PROJECT NO. 1002367	APPLICATION NO. 02DRB-01808
PROJECT NAME EL RANCITO AIRSCO #2	
EPC APPLICATION NO.	
APPLICANT / AGENT WAYJOHN // TOM JOHNSTON	PHONE NO. 255-2052
ZONE ATLAS PAGE H-10	
<b>ONE STOP COMMENT FORM LOG</b>

RE: Replat of Tract 2, El Rancho Atrisco

PLAT OF TRACT 2-A EL RANCHO ATRISCO ALBUQUERQUE, BERNALILLO COUNTY, NEW MEXICO

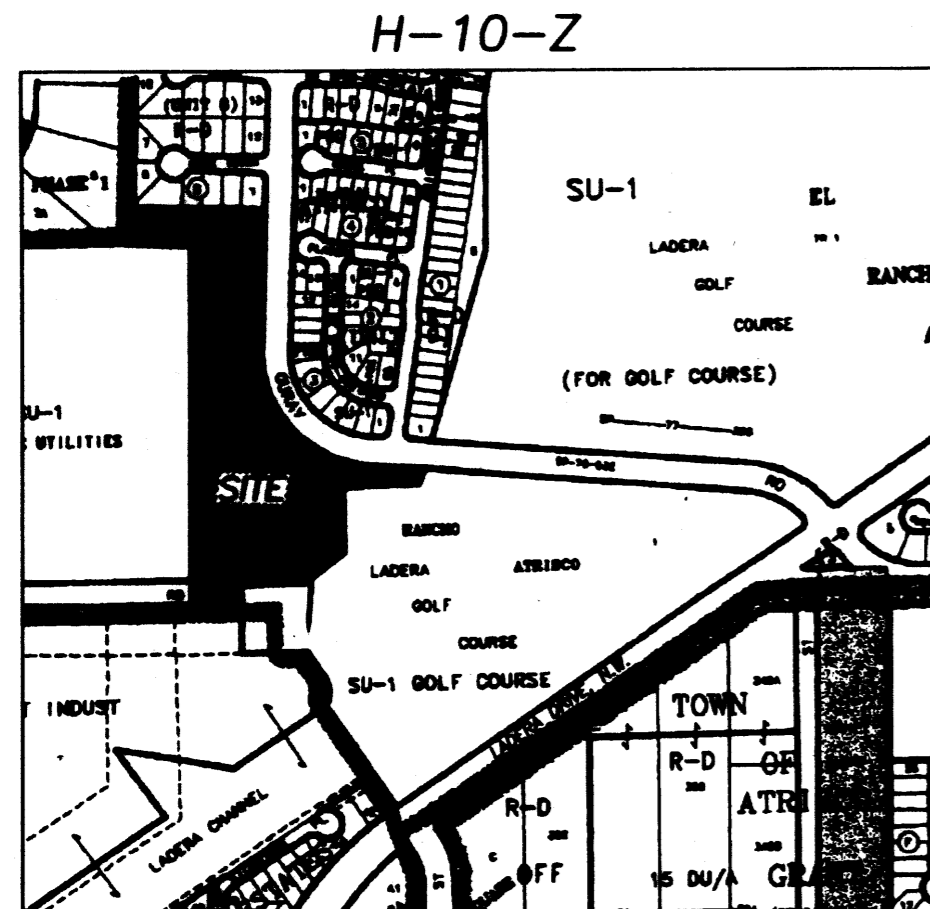
<b>HYDROLOGY DEV (505) 924-3986</b>		
PLANS DISAPPROVED <i>BLB</i>	DATE 12/02/02	DATE
PLANS APPROVED <i>BLB</i>	DATE 12/02/02	DATE
COMMENTS:		
<del>Explain Beneficiary to maintenance of drainage easement. describe if private or public.</del> <i>AS - Tom has addressed issues.</i> <span style="float: right;">ok</span>		
<i>AMAFCA must sign since it adjoin their facility</i>
